Project Name: ROSEMONT PARK ADDITION

**CITY OF ALBUQUERQUE
PLANNING DEPARTMENT
May 21, 2008
DRB Comments**

APPLICATION # 08-70217

RE: Lots 1-3, Block 2, Rosemont Park Additon

**PLAT OF
LOTS 1-A, 2-A AND 3-A
BLOCK 2
ROSEMONT PARK ADDITION**
WITHIN
TOWN OF ALBUQUERQUE GRANT
PROJECTED SECTION 18, TOWNSHIP 10 NORTH, RANGE 3 EAST, N.M.P.M.
CITY OF ALBUQUERQUE
BERNALILLO COUNTY, NEW MEXICO
APRIL, 2008

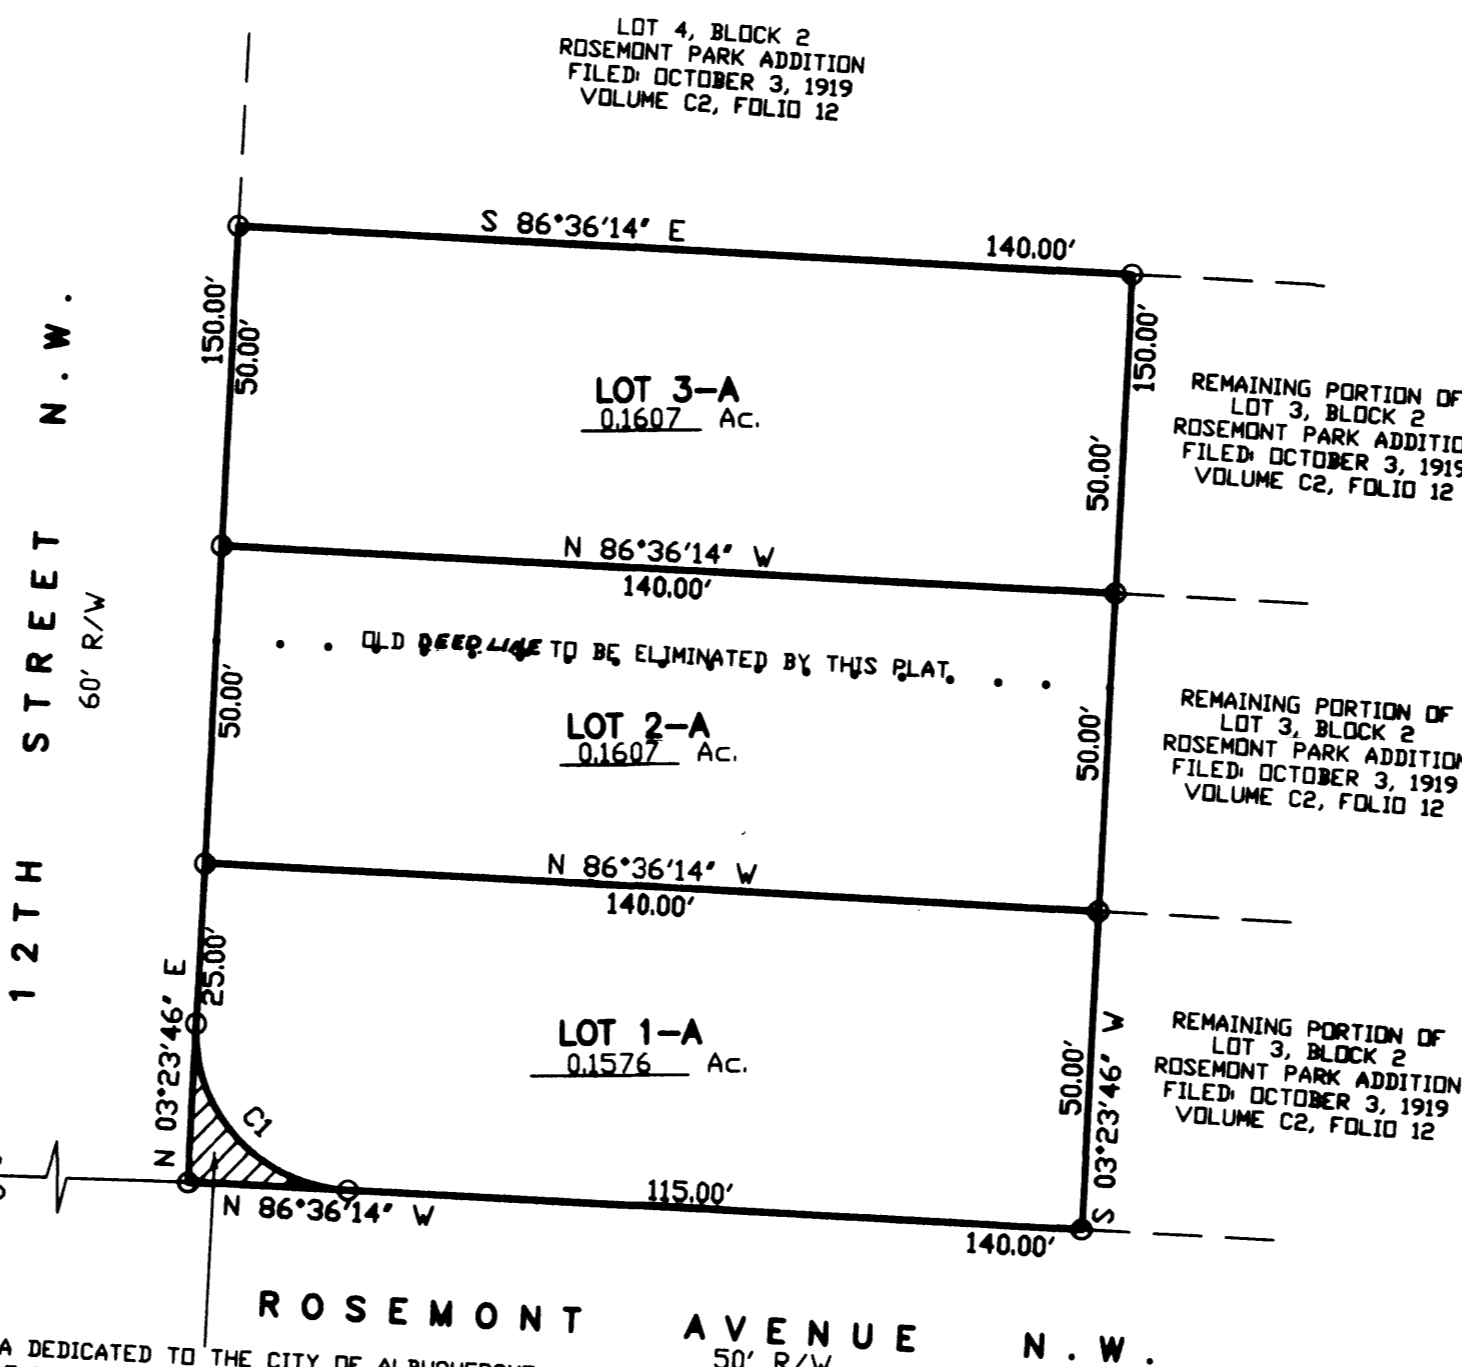
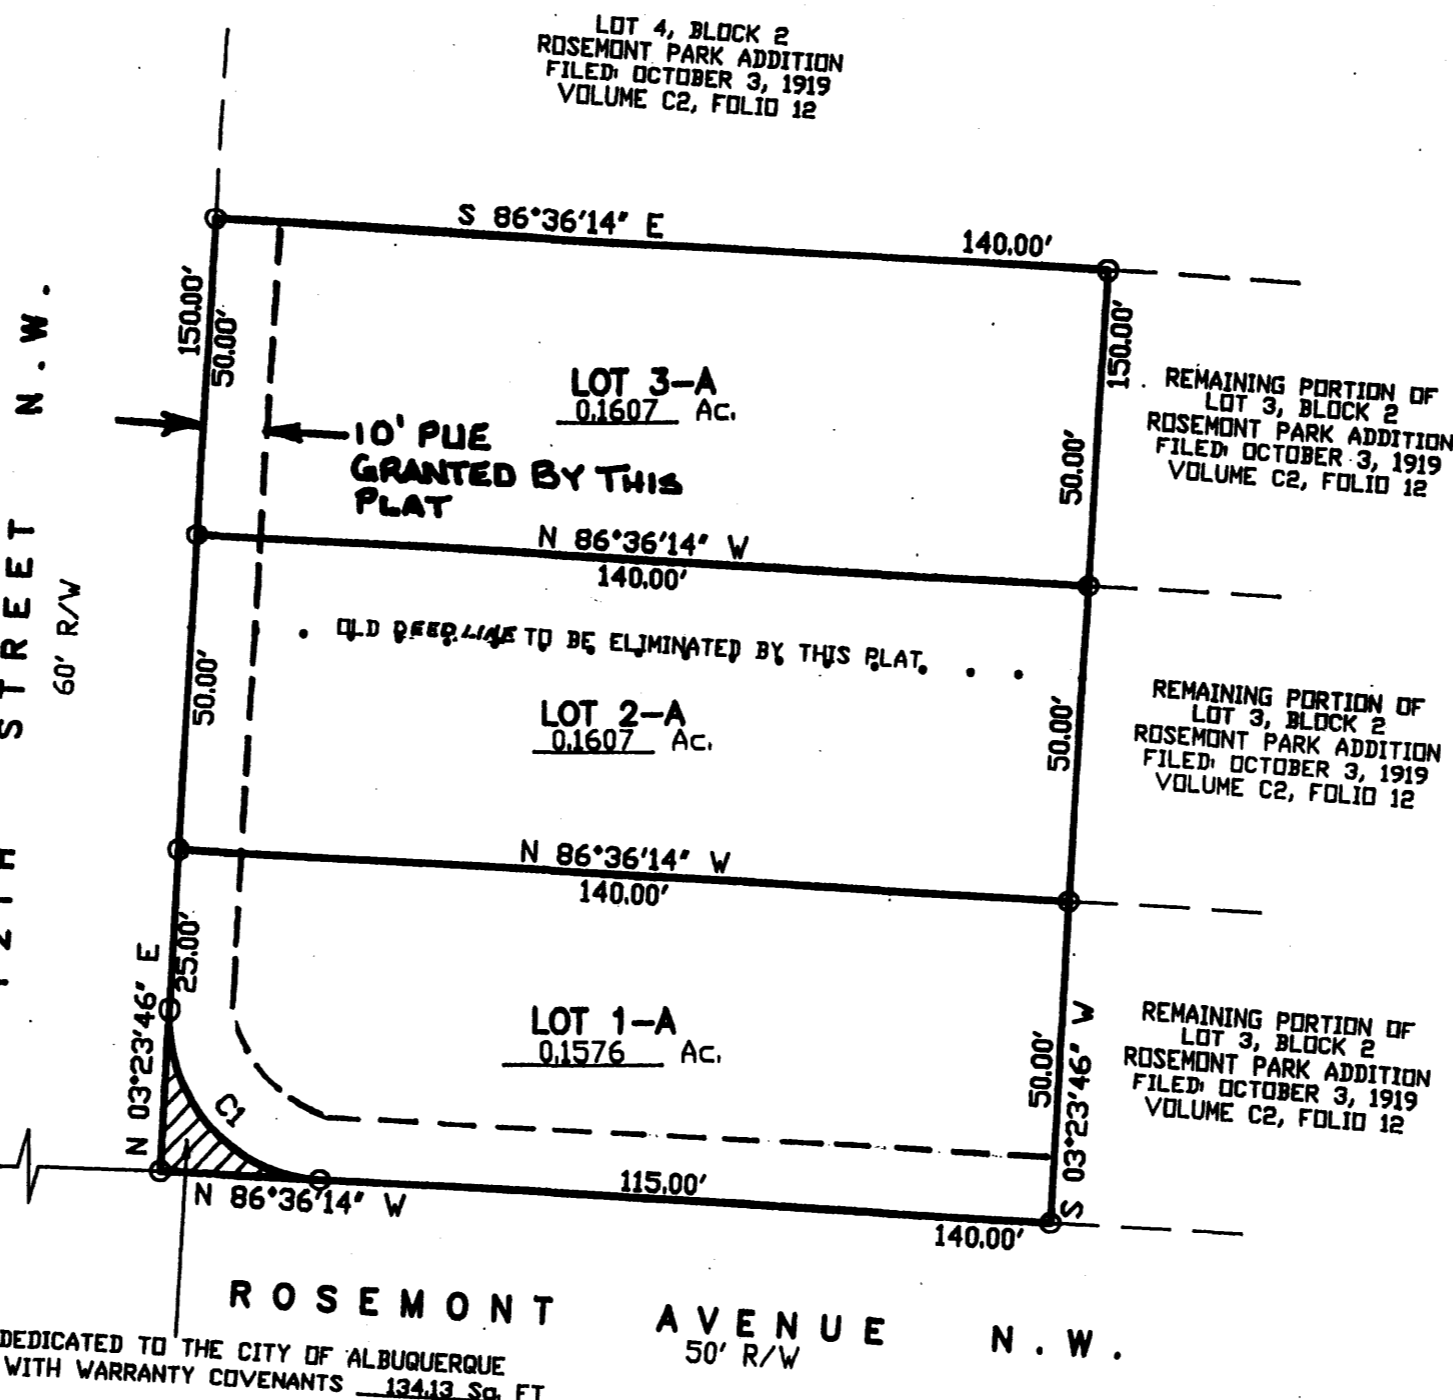
“Portions of” lots 1-3 must be documented prior to 1973 and referenced on the plat. Proposed plat is not consistent with previous sketch plat – it does not appear that proposed Lot 1-A will comply with zoning setbacks.

For future reference, please do not identify the property’s zoning (Note 9) on the plat (it is also incorrect). Also, please revise solar note (10) to be specific to this type of request, i.e. use the words “THIS PLAT” and not “REQUESTED FINAL ACTION.”
